## DEPARTMENT OF PARKS AND COMMUNITY SERVICES

October 3, 2024

**Subject: Flying Horse North Phase Filing No. 4 PUD Development Plan and Preliminary Plan Amendment (PUDSP-24-004) and Final Plat (SF-24-022)**

PUD PRELIMINARY PLAN MINOR AMENDMENT
 OVERALL SITE PLAN AND ADJACENT OWNERS

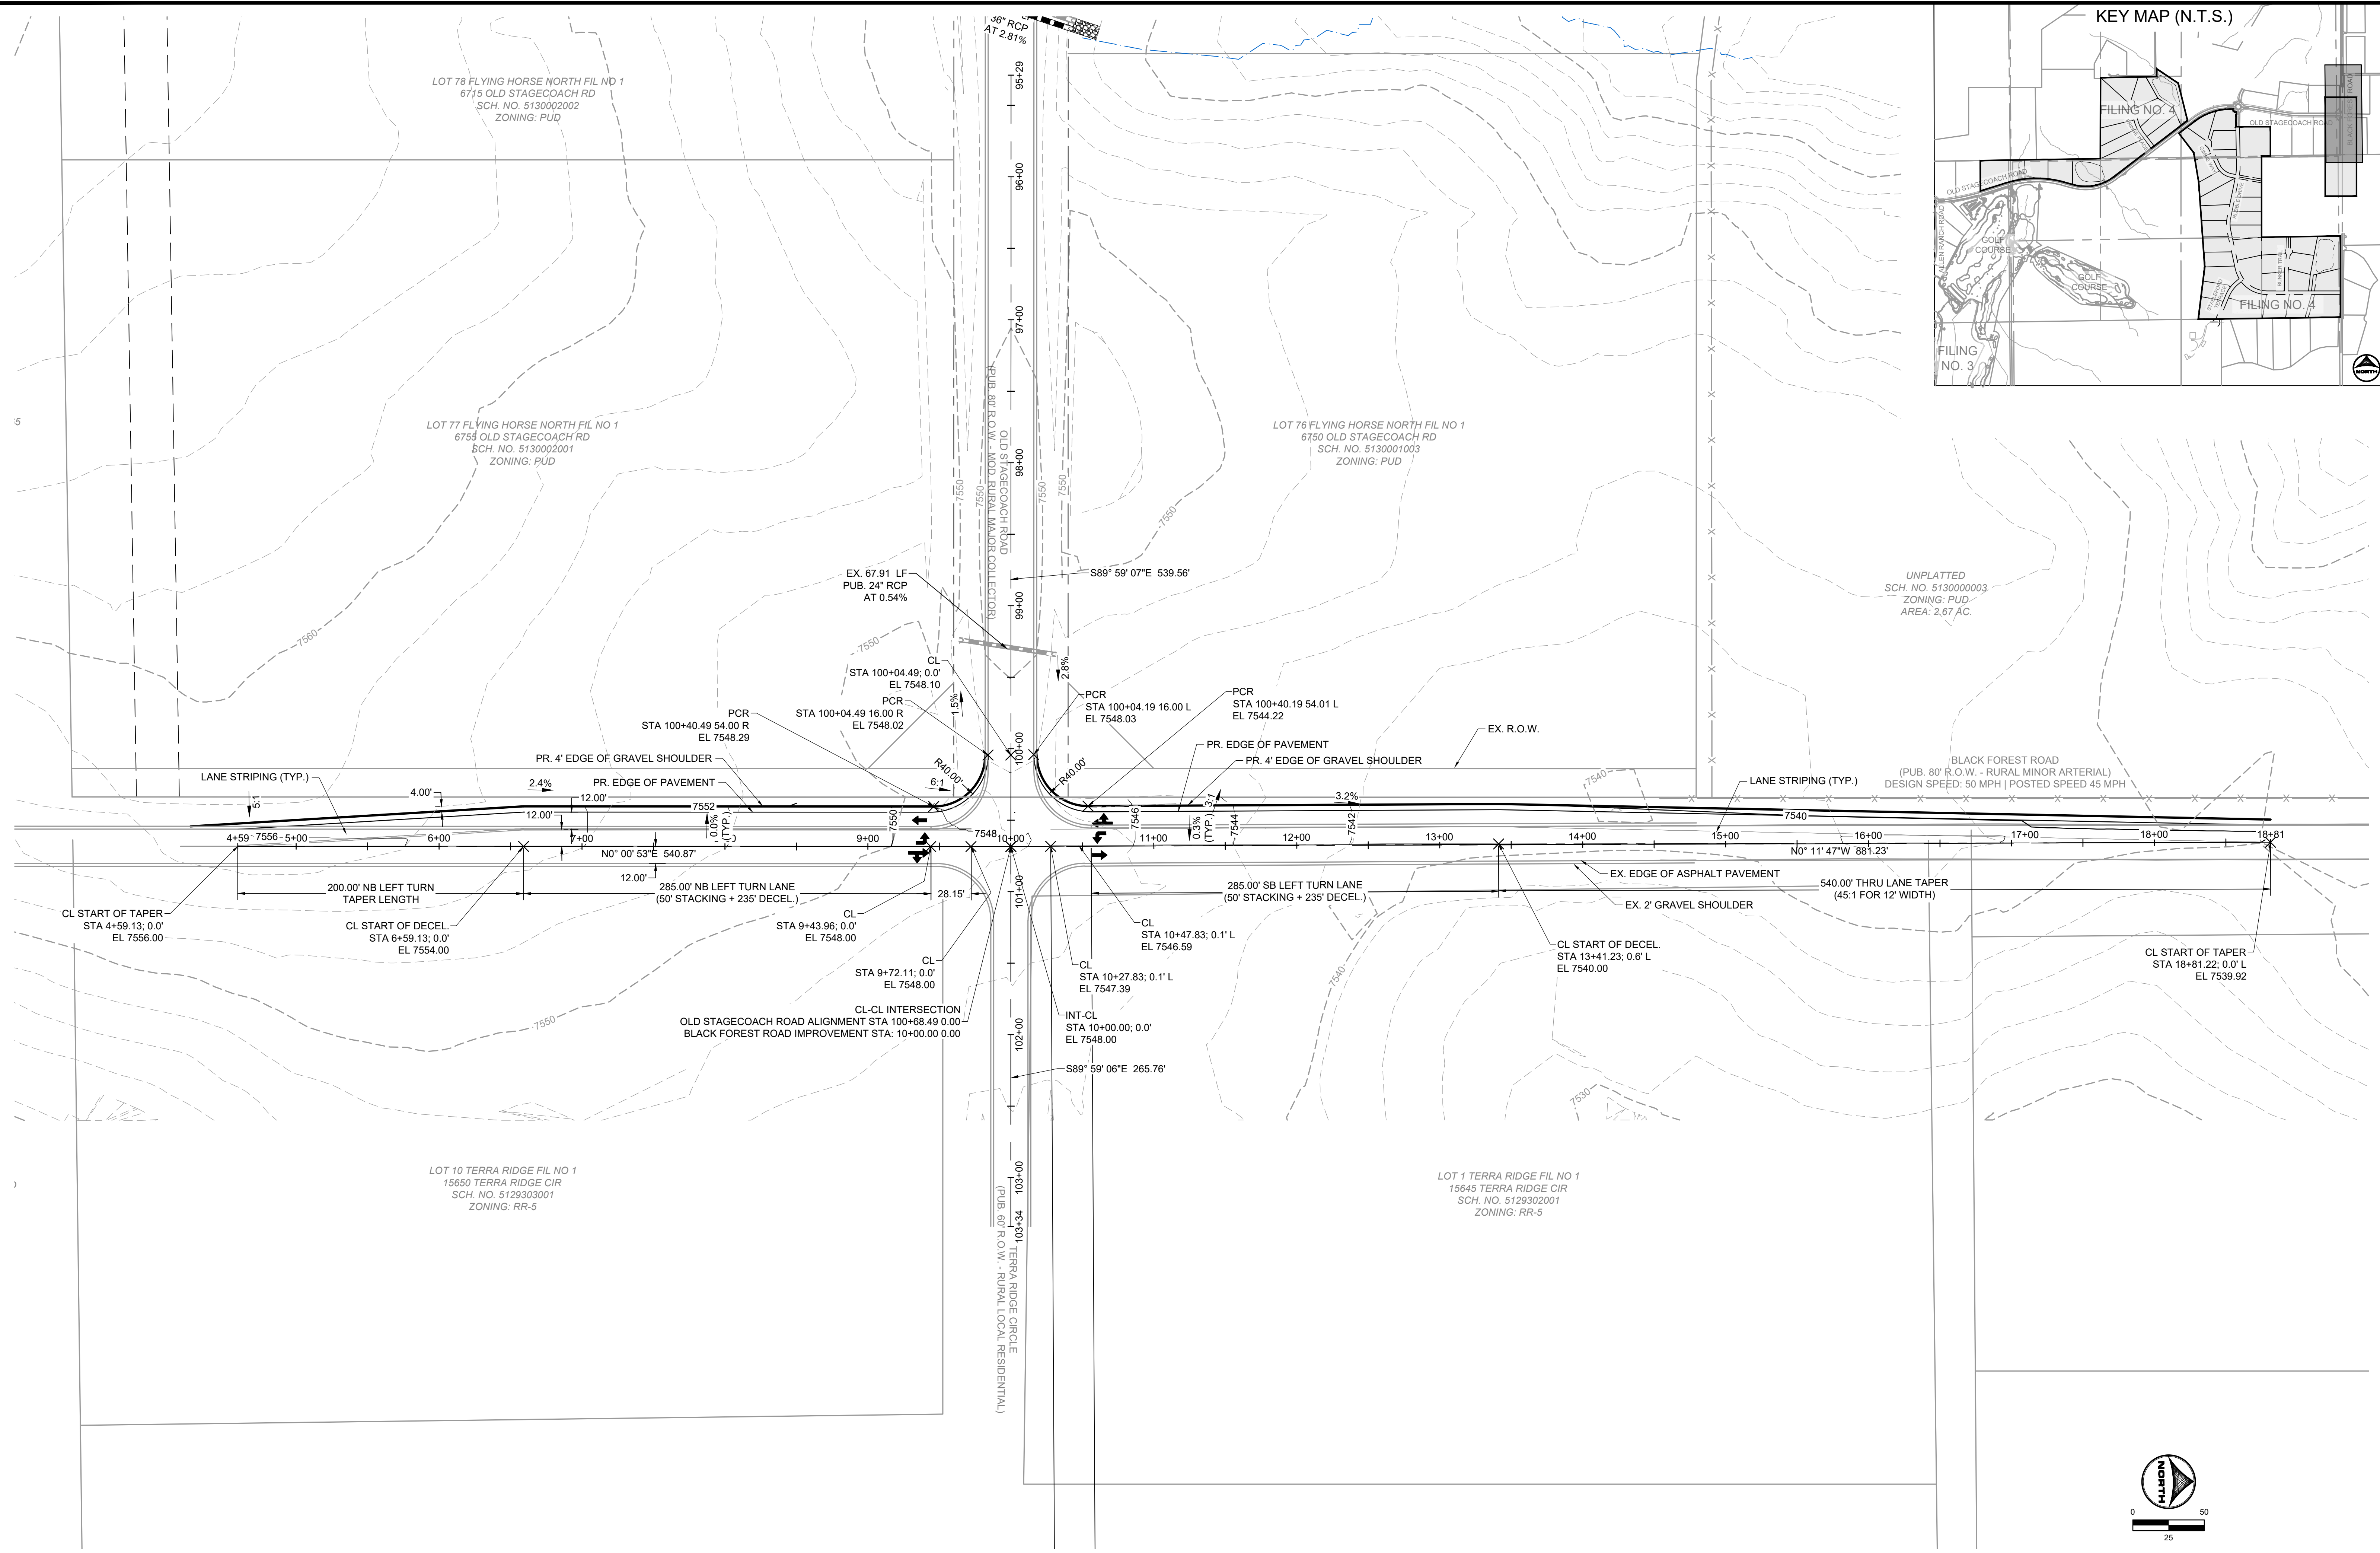
Lastly, the submitted PUD Development Plan and Preliminary Plan Amendment and Final Plat both show a “20’ Regional Trail Easement” located at the far southwestern corner of Filing No. 4. A conversation with HR Green revealed that this is actually an internal trail that will connect to the Fox Run Regional Trail and therefore should not be identified as a regional trail, nor an easement dedicated to El Paso County. However, the Trails Exhibit does show the Fox Run Regional Trail running east-west through the northern portion of Filing No. 4, along Old Stagecoach Road. As such, staff requires a 25’ public trail easement to be located on the southern side of Old Stagecoach Road, through Lots 31-33, and dedicated to El Paso County on this Final Plat.

*The Park Advisory Board recommends that the Planning Commission and the Board of County Commissioners include the following conditions when considering and/or approving the Flying Horse North Filing No. 4 Final Plat: (1) designate and provide to El Paso County 25-foot wide public regional trail easement along the south side of Old Stagecoach Road through Filing No. 4 that allows for public access, as well as construction and maintenance by El Paso County of the Fox Run Primary Regional Trail, and the easement be shown, noted, and dedicated to the County via this Final Plat; and (2) fees in lieu of land dedication for regional park purposes in the amount of \$24,240 will be required at time of the recording of this Final Plat.*
